Your Ref: SSI 6878
Our Ref: Z17/442770
File: DE-2015/16
Date: 27 September 2017

ALBION PARK RAIL BYPASS STATE SIGNIFICANT INFRASTRUCTURE PROPOSAL (SSI 6878) – PREFERRED INFRASTRUCTURE REPORT

David Farmer
General Manager
Wollongong City Council
Telephone: (02) 4227 7111

LEGEND

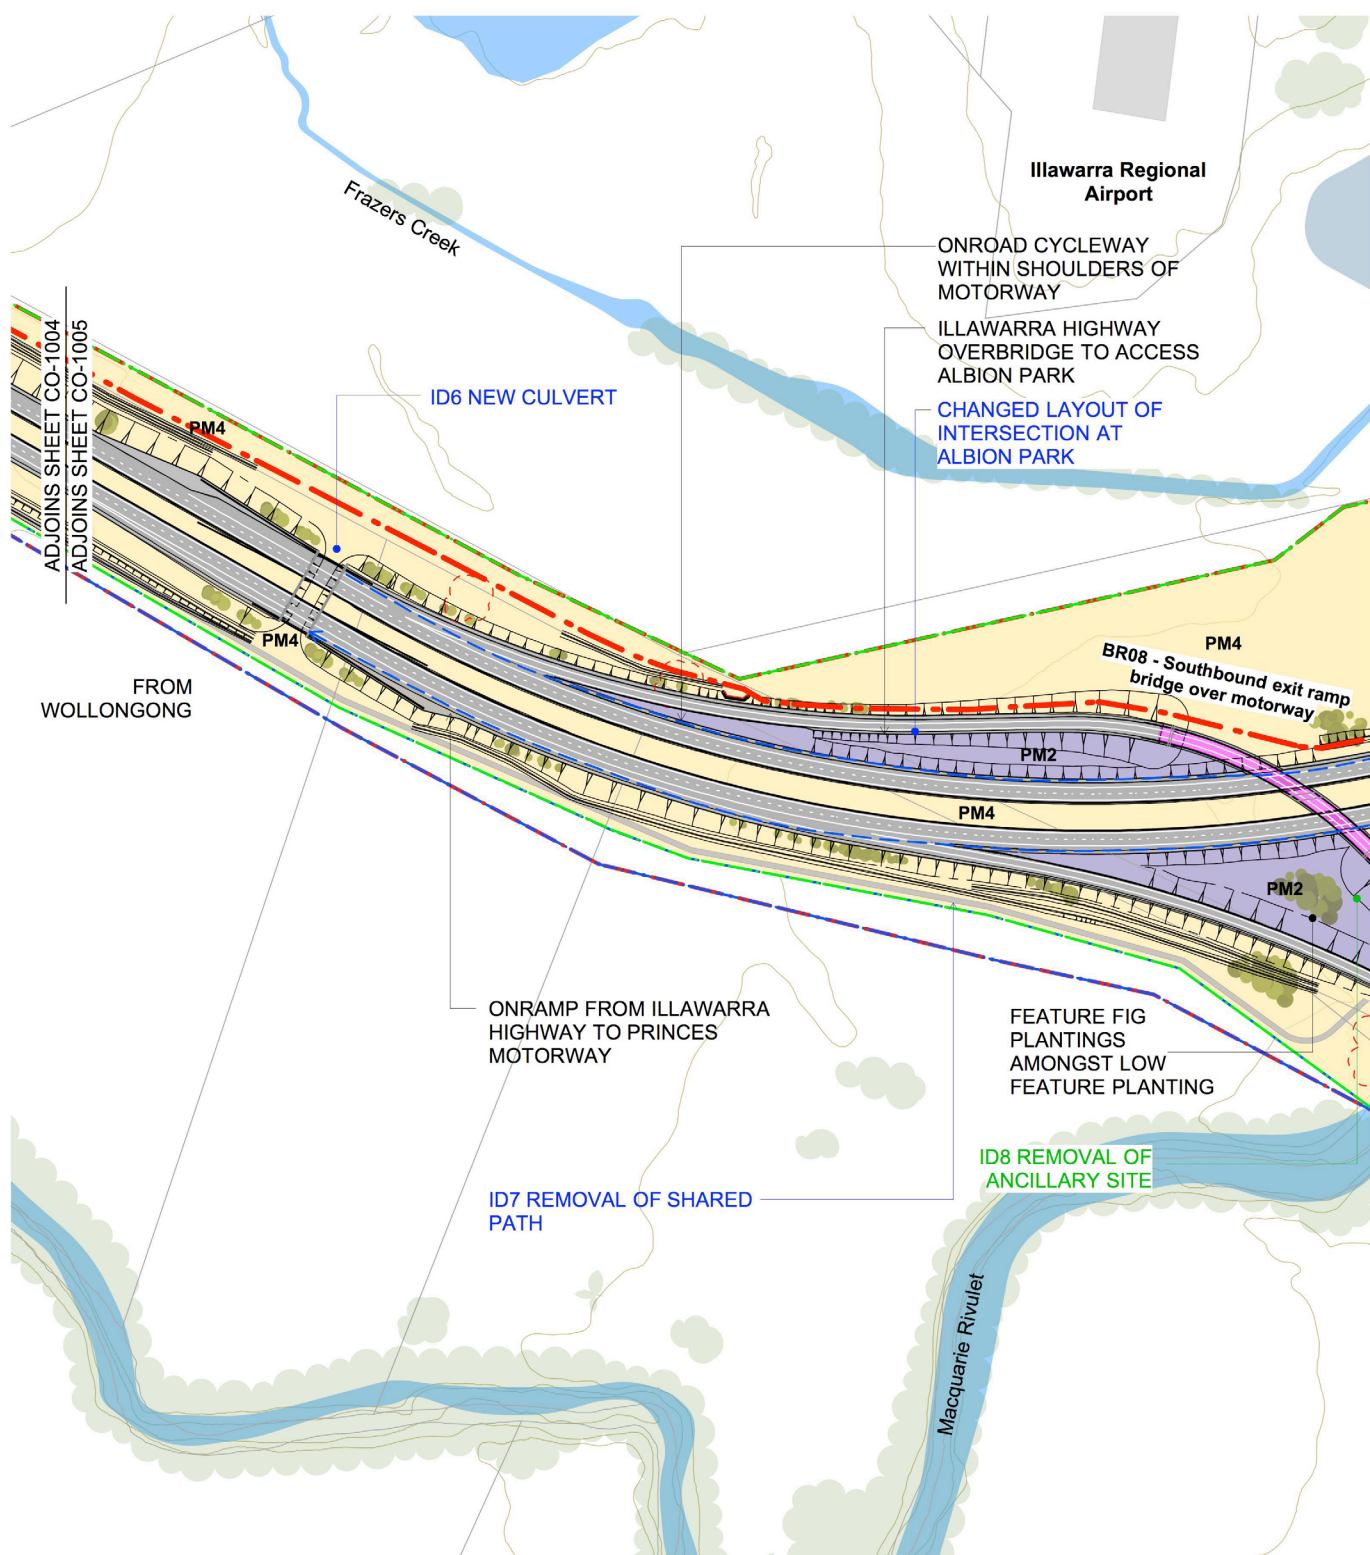
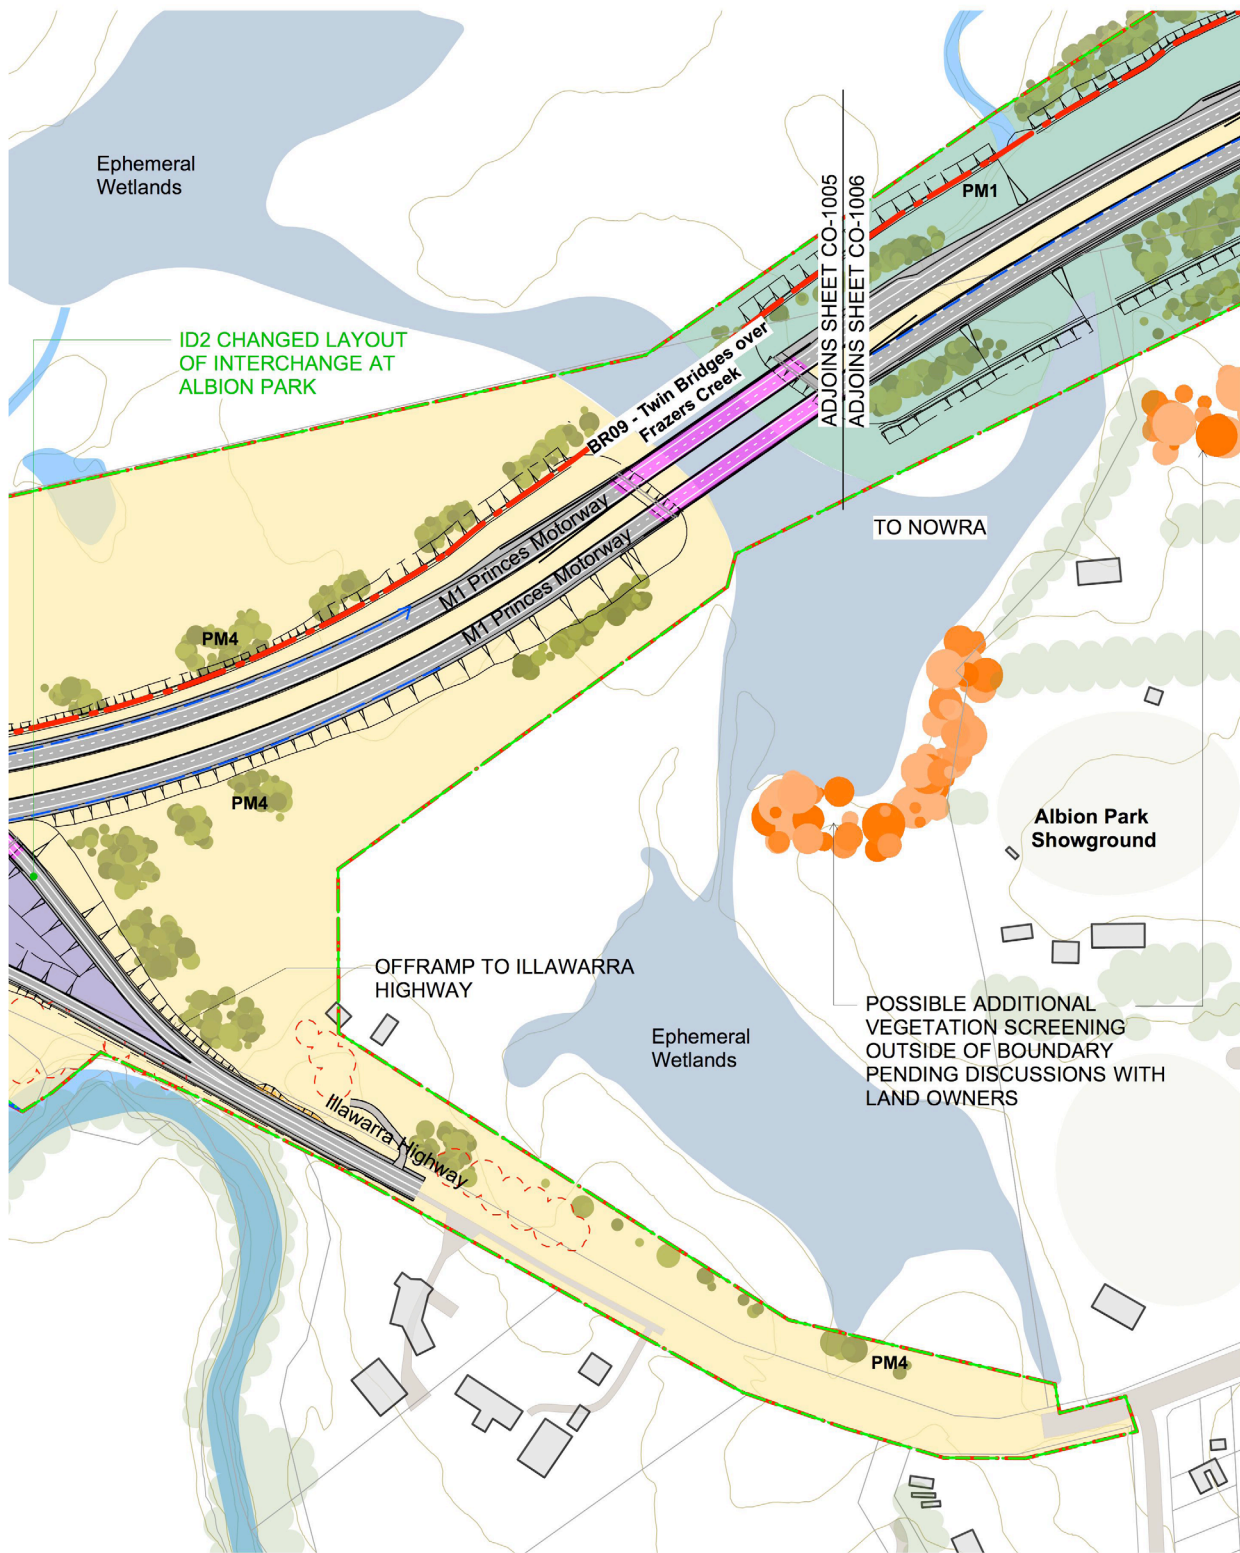
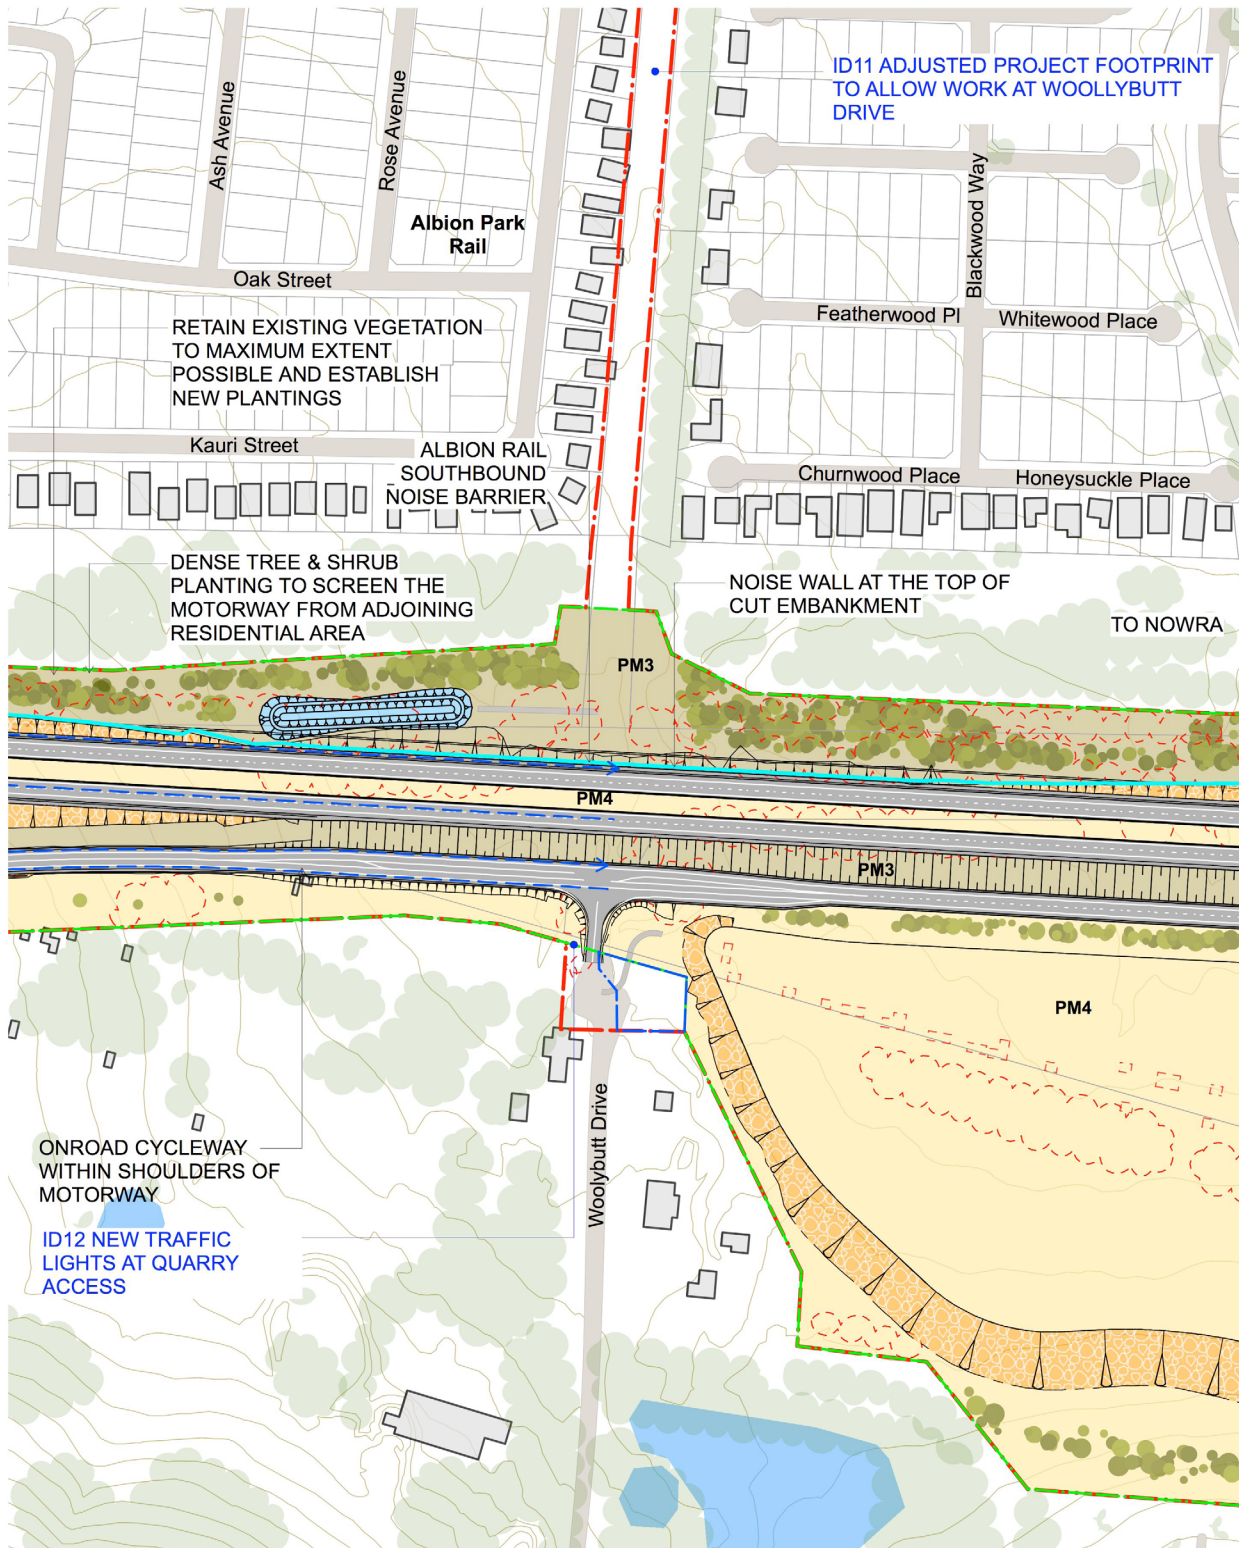
The final Landscape Plan should indicate all proposed tree removals, include compensatory provision for the trees required to be removed and include a more extensive list of natives grasses and groundcovers for proposed plant mix 2 (PM2)- feature planting.
